DECISION DELEGATED TO HEAD OF PLANNING

Application No: H11-1055-23 **Applicant:** Mr & Mrs K Kearns
Proposal: Extension & Alterations
Location: 17 Windsor Gardens Long Sutton Spalding
Terminal Date: 2nd February 2024

PROPOSED
FLOOR PLANS & ELEVATION
SITE PLAN

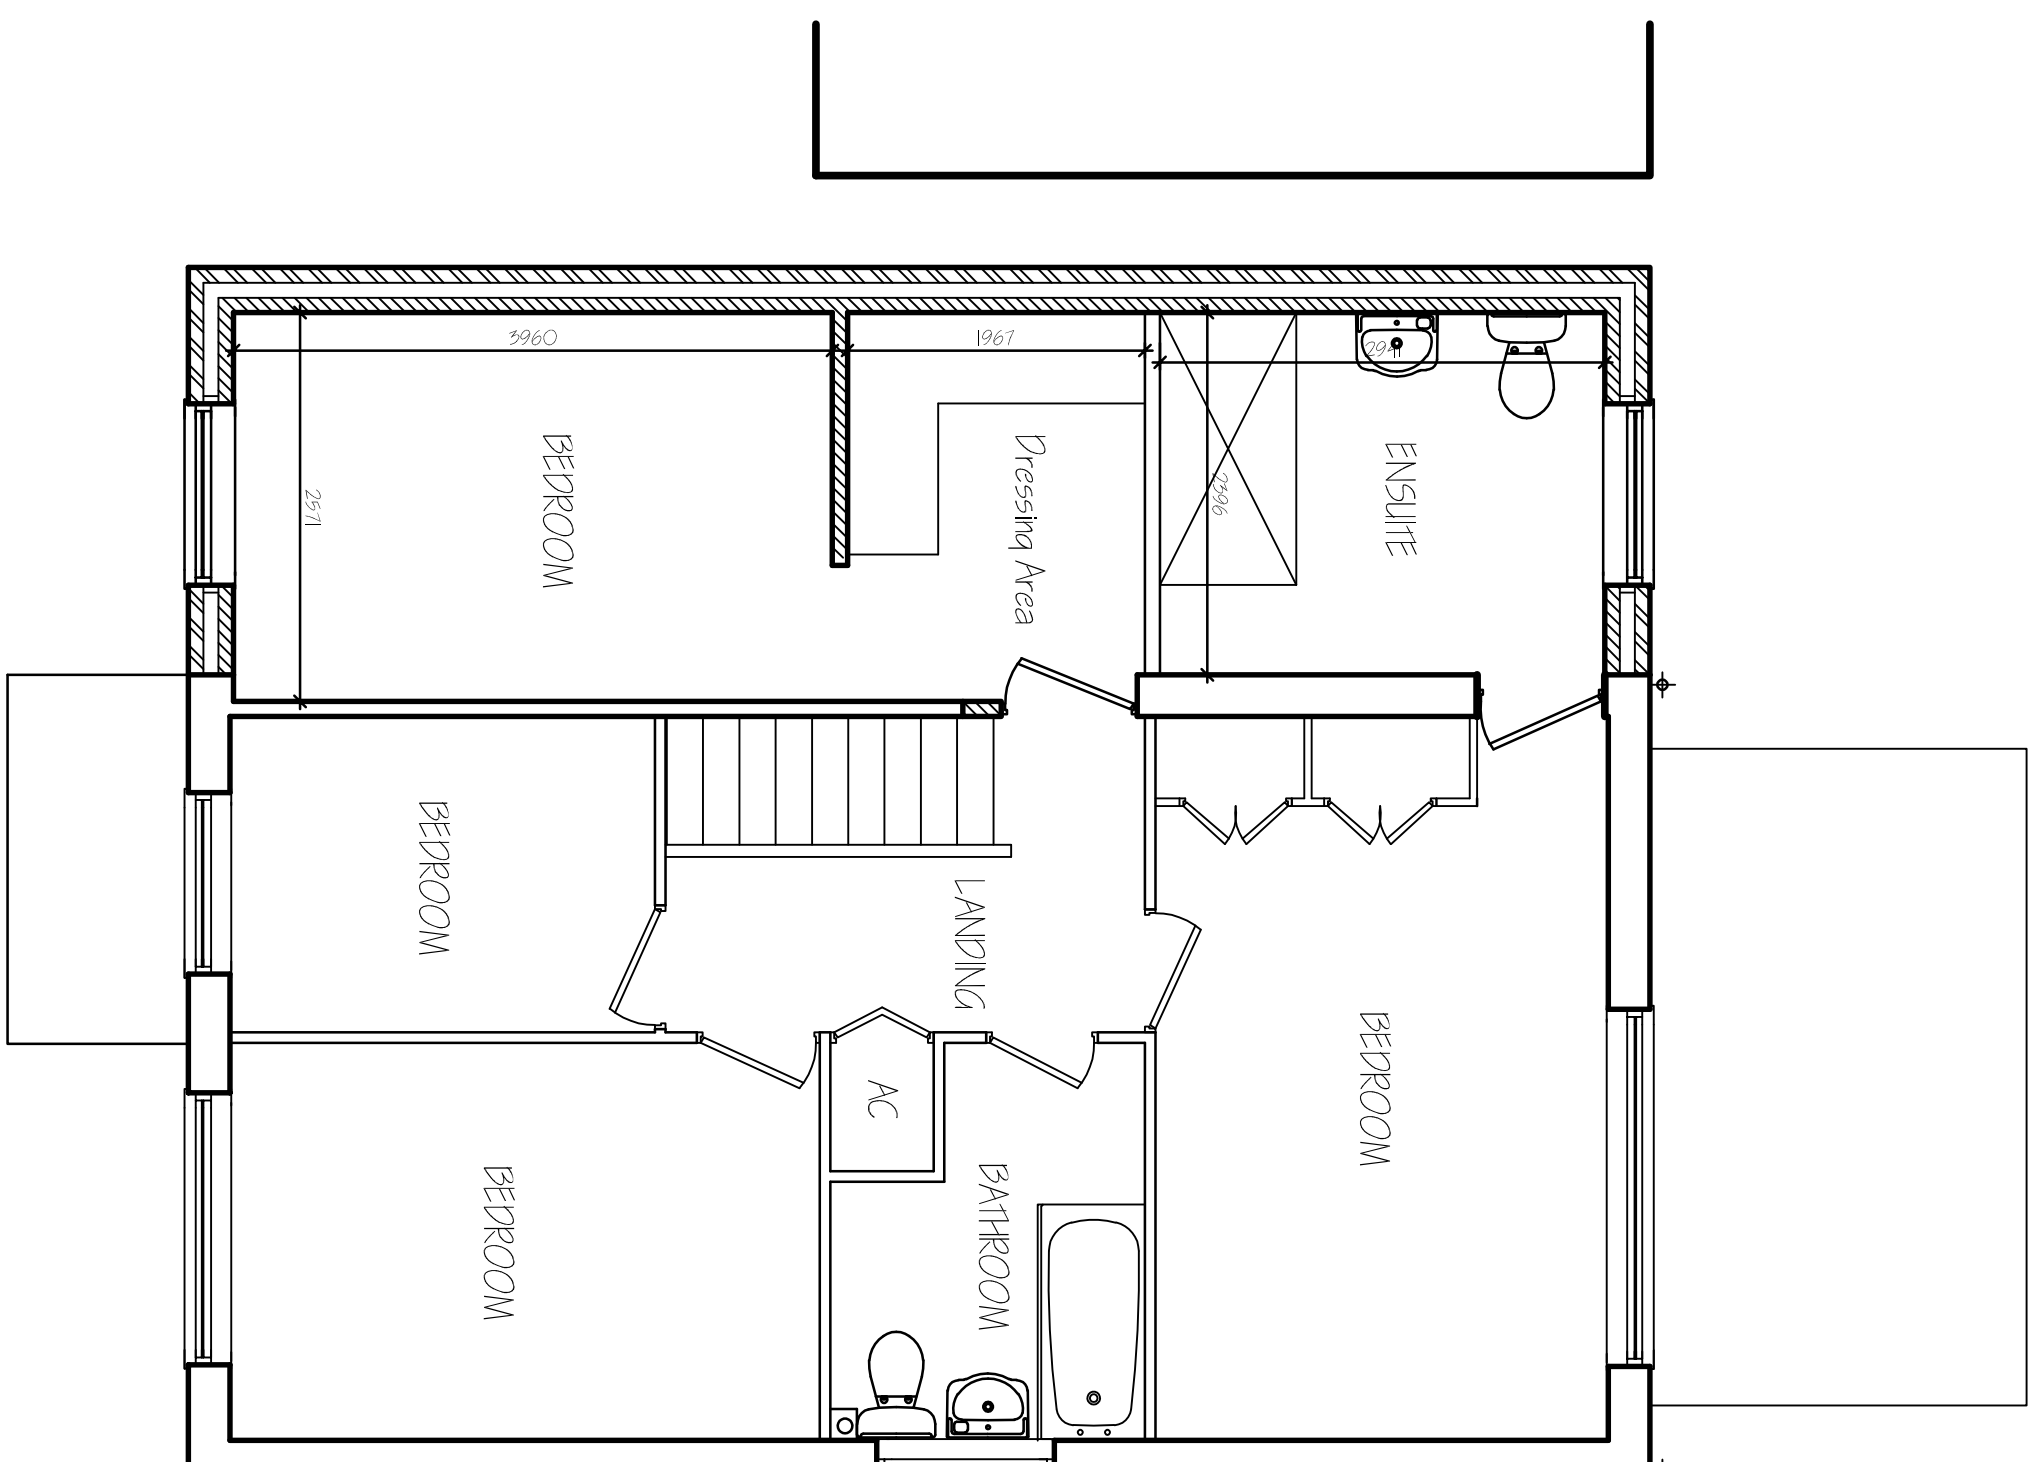
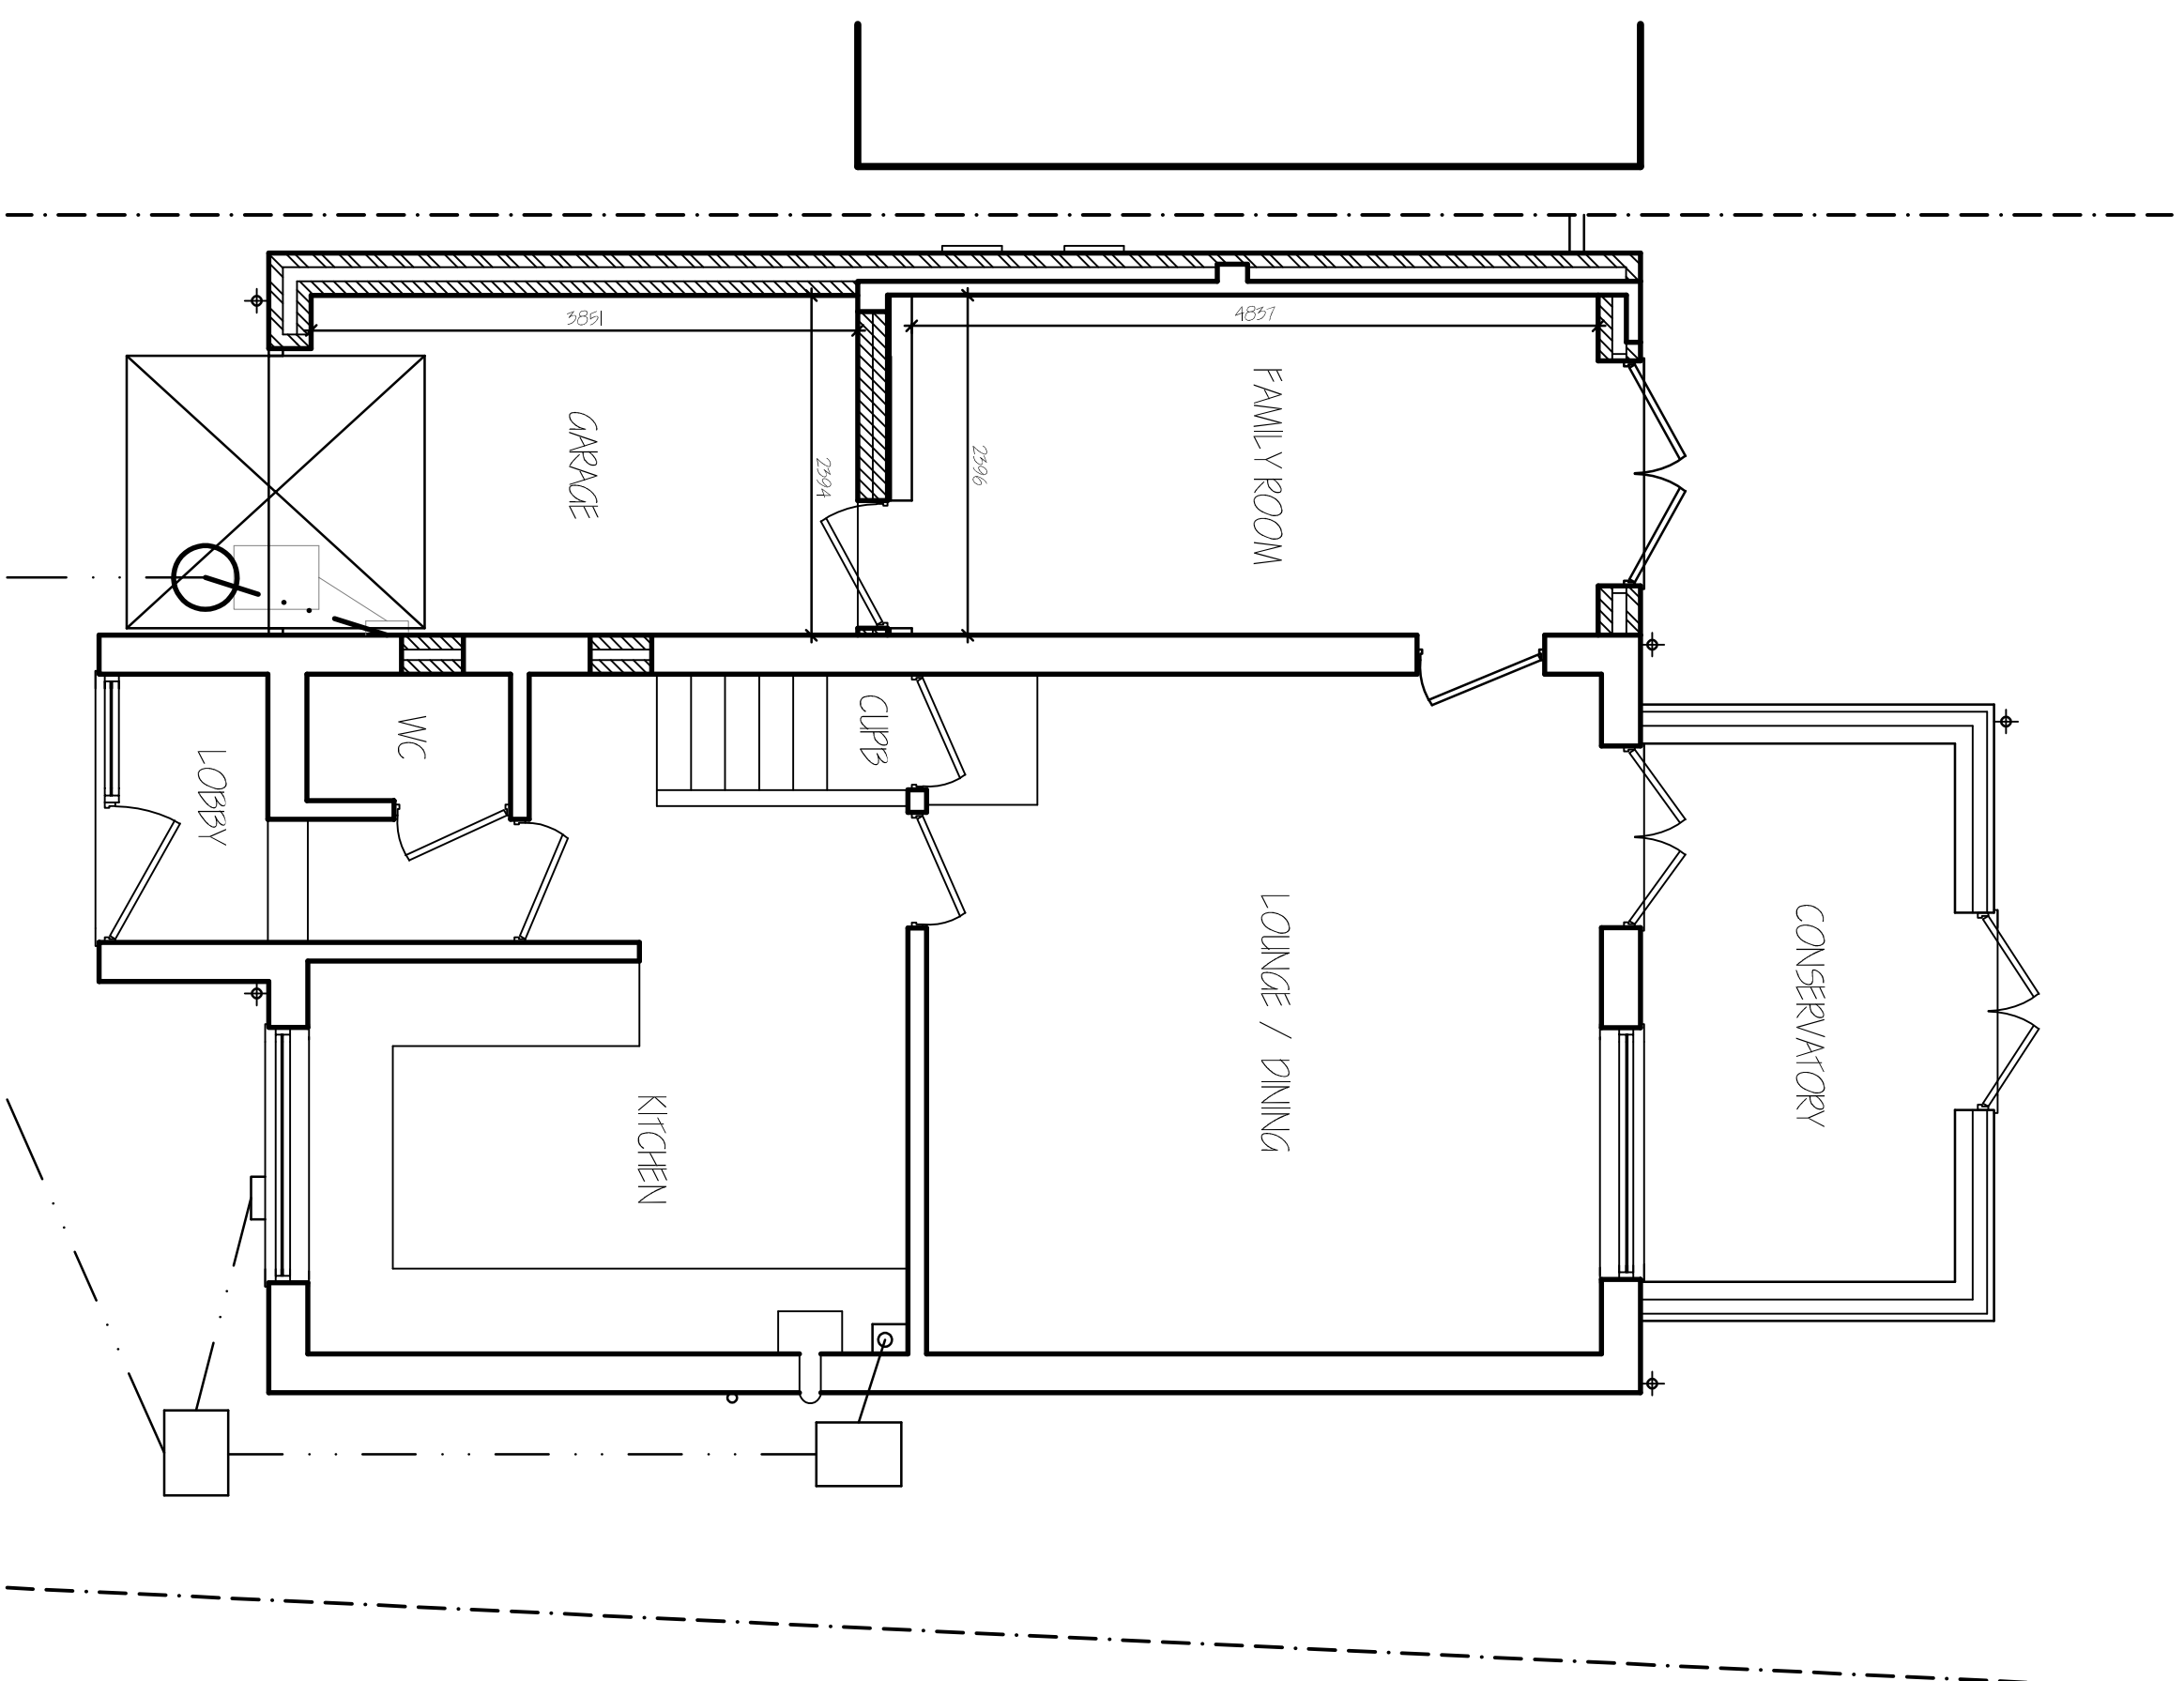
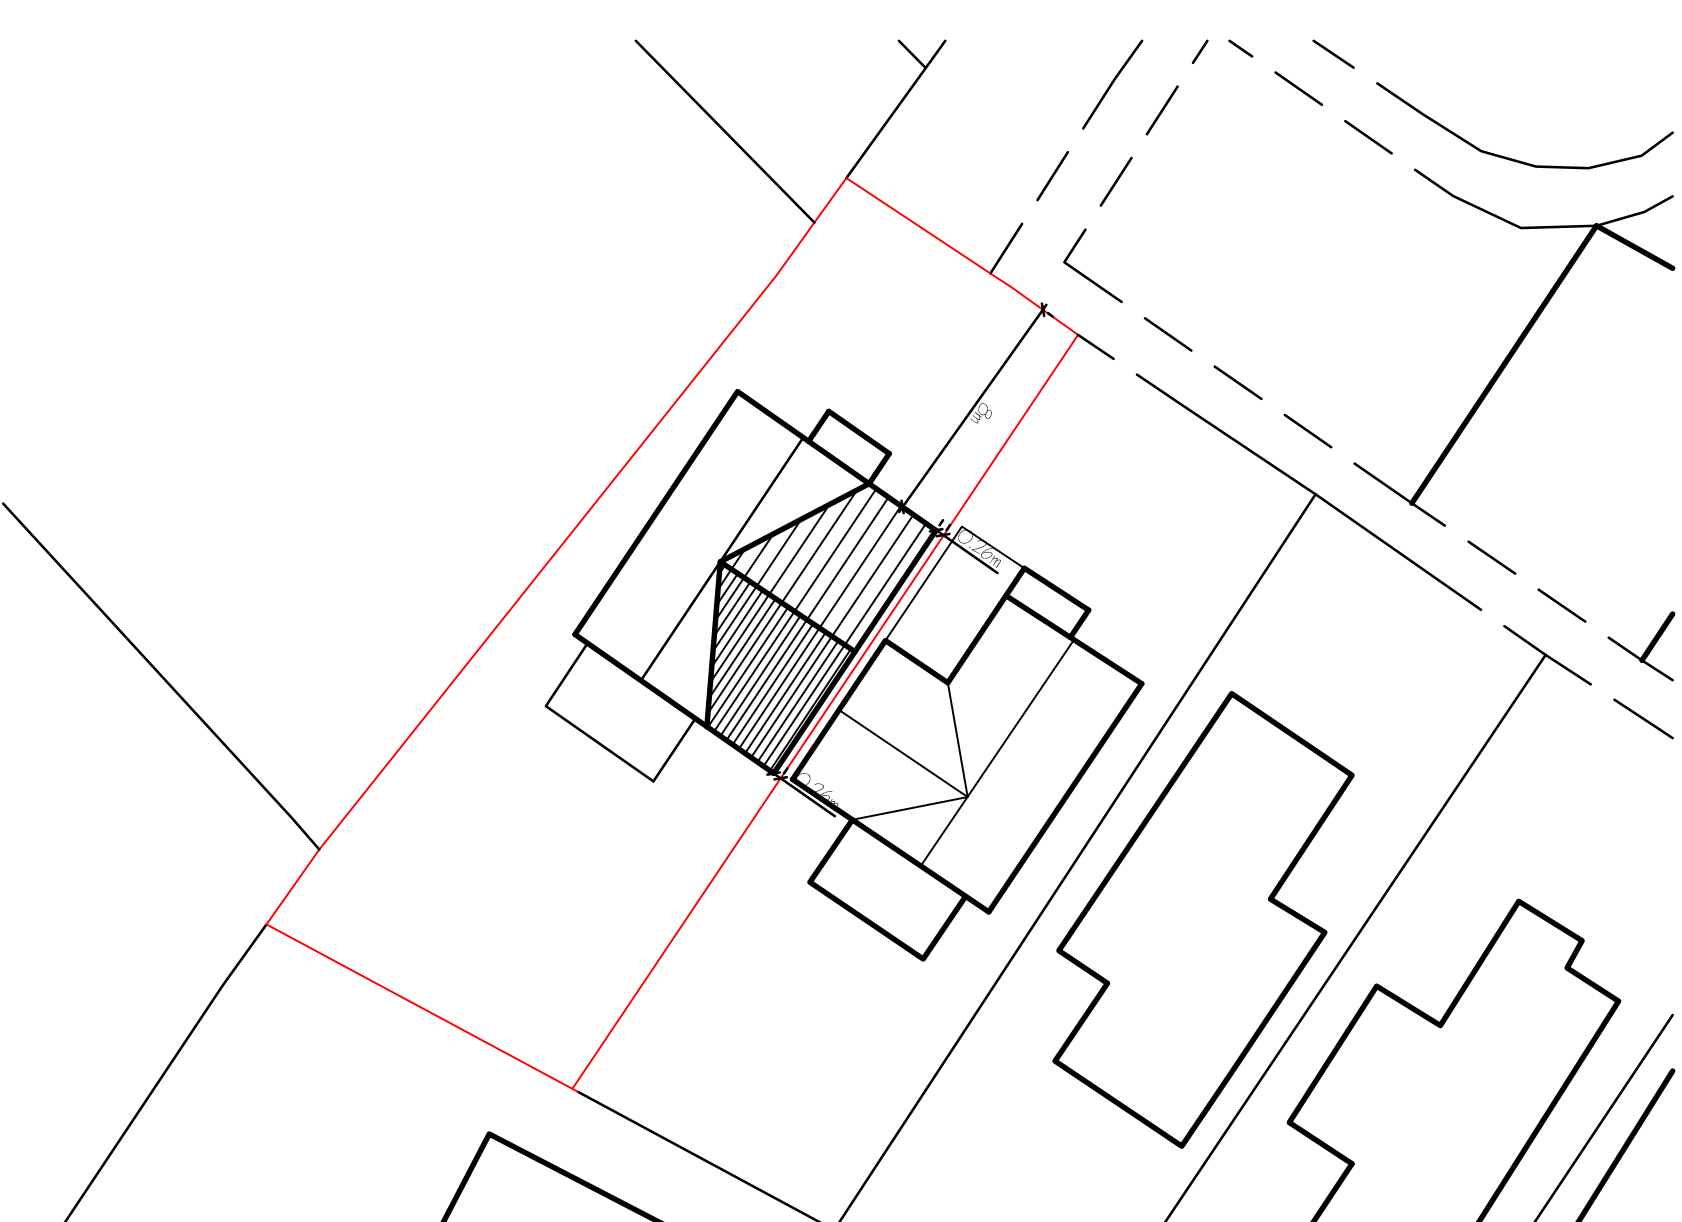
The ground floor section of the extension will protrude from the side elevation by around 2700mm and project from the front of the existing garage by 4100mm. Above this, the first floor extension will run the full length to be level with the ground floor section, as such it has a total length of approximately 9700mm whilst projecting from the side by around 2700mm. Both the eaves and ridge heights will be level with the existing dwelling coming up to 4700mm and 6500 respectively. By design, the extension appears out of character and unsympathetic with the neighbouring property, No. 15 had an extension approved under H11-1094-88 which was of a similar style however it was set much further back within the property and therefore now makes the house a sort of L shape with a small car port overhanging. The proposed extension at No. 17 would appear more suitable for the area if it incorporated a similar design to this whilst also dropping the ridge height so it looks more subordinate at the same time, by failing to introduce either of these designs it means

the extension conflicts with Policies 2 and 3 of the SELLP and Section 12 of the NPPF and should be refused for this reason.

Furthermore, as part of the development there will be some alterations taking place. Internally, the existing garage will be converted into a family room whilst the garage will be situated in the front of the ground floor extension. Access to this new family room will be provided through a new door in the lounge/ dining area. There shall be a new set of bi-fold doors at the rear allowing access into the garden from this room. On the first floor the master bedroom will be opened into the extension to now feature an en-suite for the residents, alongside this, there will now be room for an extra bedroom with a dressing area. Many of these alterations do not require planning permission but have been listed within the plans and therefore mentioned in the report.

There shall be no overlooking as a result of this development being carried out, there shall be no windows on the side elevation where the extension is being developed and as such there is no window that will provide a clear view into a neighbouring property. A window shall be featured at the rear, however, this will act as an en-suite and due to the nature of the room it will be obscure glazed and therefore will not result in a loss of privacy.
